**Reference TR010063 - Application by Gloucestershire County Council for an Order Granting Development Consent for the M5 Junction 10 Highway Improvements Scheme**

**Deadline 4 Submissions by Bloor Homes Limited and Persimmon Homes Limited (Interested Party Reference Numbers 20047701 and 20047702) (together the Interested Parties)**

WRITTEN POST HEARING SUBMISSIONS INCLUDING WRITTEN SUBMISSIONS OF ORAL CASES MADE AT THE ISSUE SPECIFIC HEARING 3 (ISH3) AND COMPULSORY ACQUISITION HEARING 1 (CAH1) W/C 12 AUGUST 2024

Appendix D. Current road frontage plan in response to ISH3.13

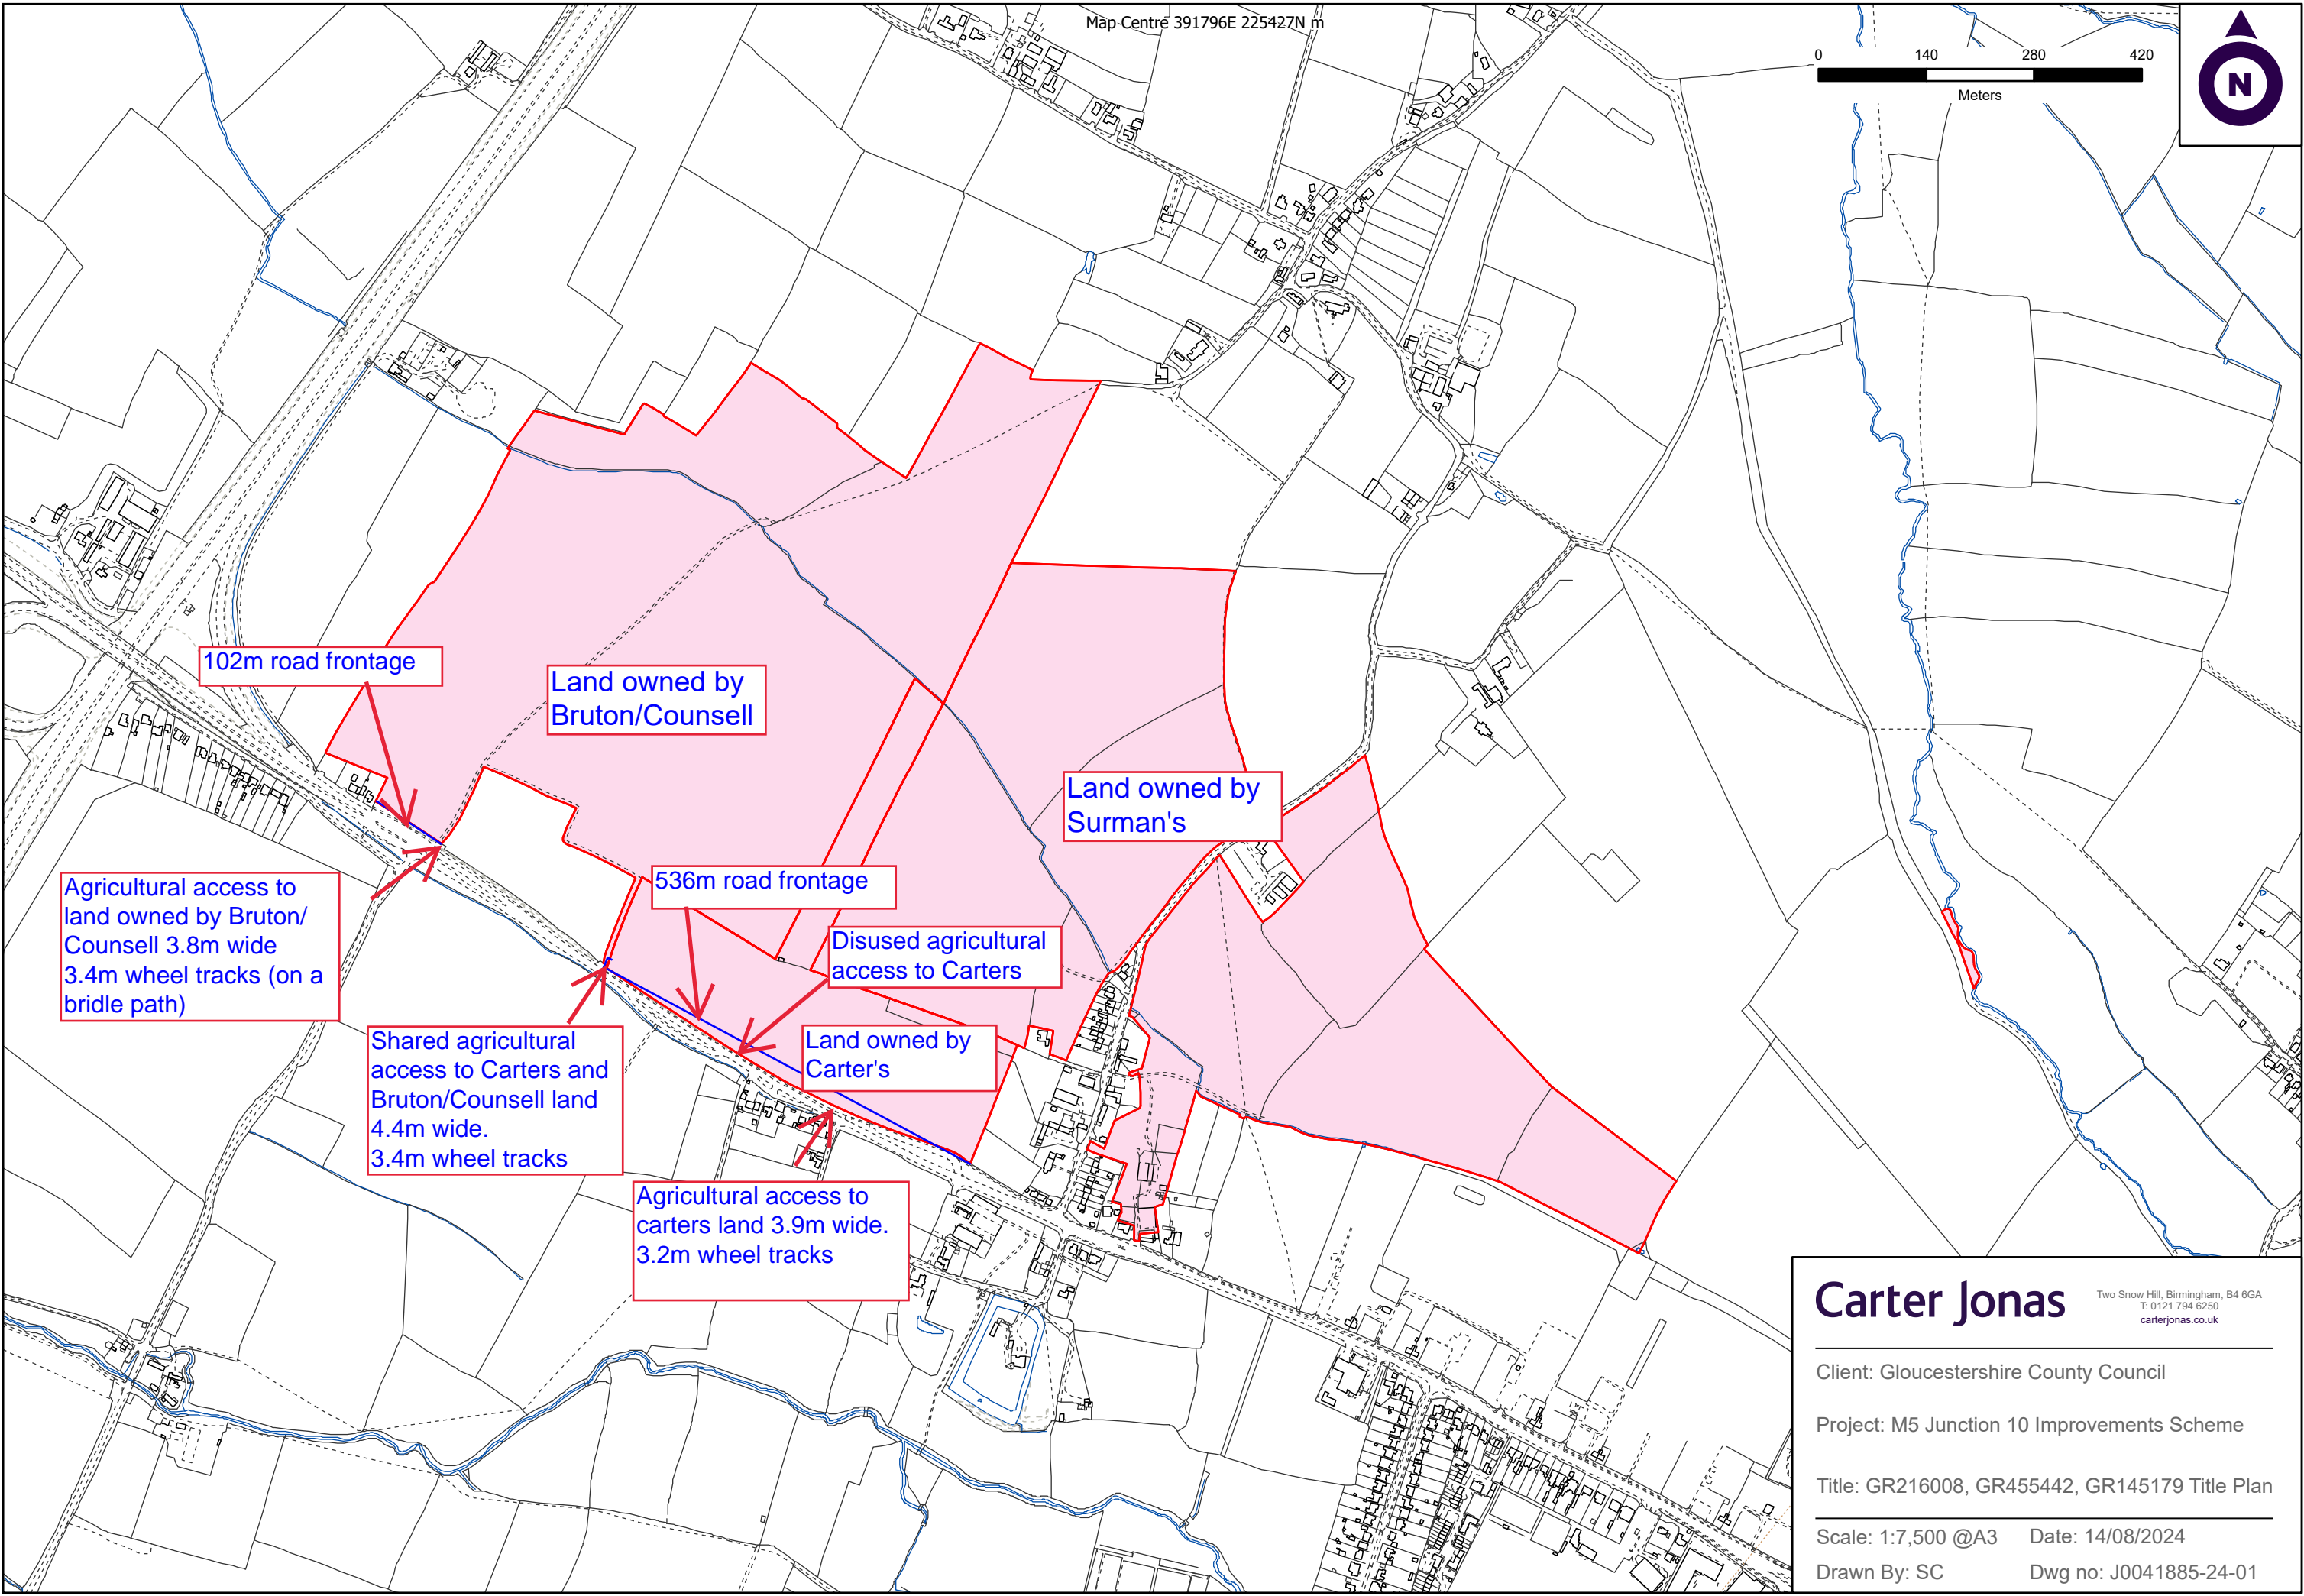
- 1.14 In the existing road arrangement, the landowner and Bloor Homes benefit from an extensive road frontage onto the A4019, which provides opportunities to create accesses to serve development of the Safeguarded Land.

- 1.15 With the Scheme as proposed, the design is such that future access is intended to be limited to a single location, within land owned by the Applicant. It has been confirmed by the Applicant that they intend to lever this arrangement to create a 'ransom' situation to its own benefit, whilst at the same time indicating it is reliant on funding from the Safeguarded Land to deliver the Scheme. The Applicant is therefore impeding delivery of development of the Safeguarded Land and putting into doubt the availability of funding on which it is relying. The Scheme should be facilitating not impeding delivery of the Safeguarded Land.

- 1.16 Likewise, the Applicant has yet to confirm that the future highway boundary will align with the revised boundary of land within the control of the landowner and Bloor Homes and that there will not be any retained strips of land restricting access.
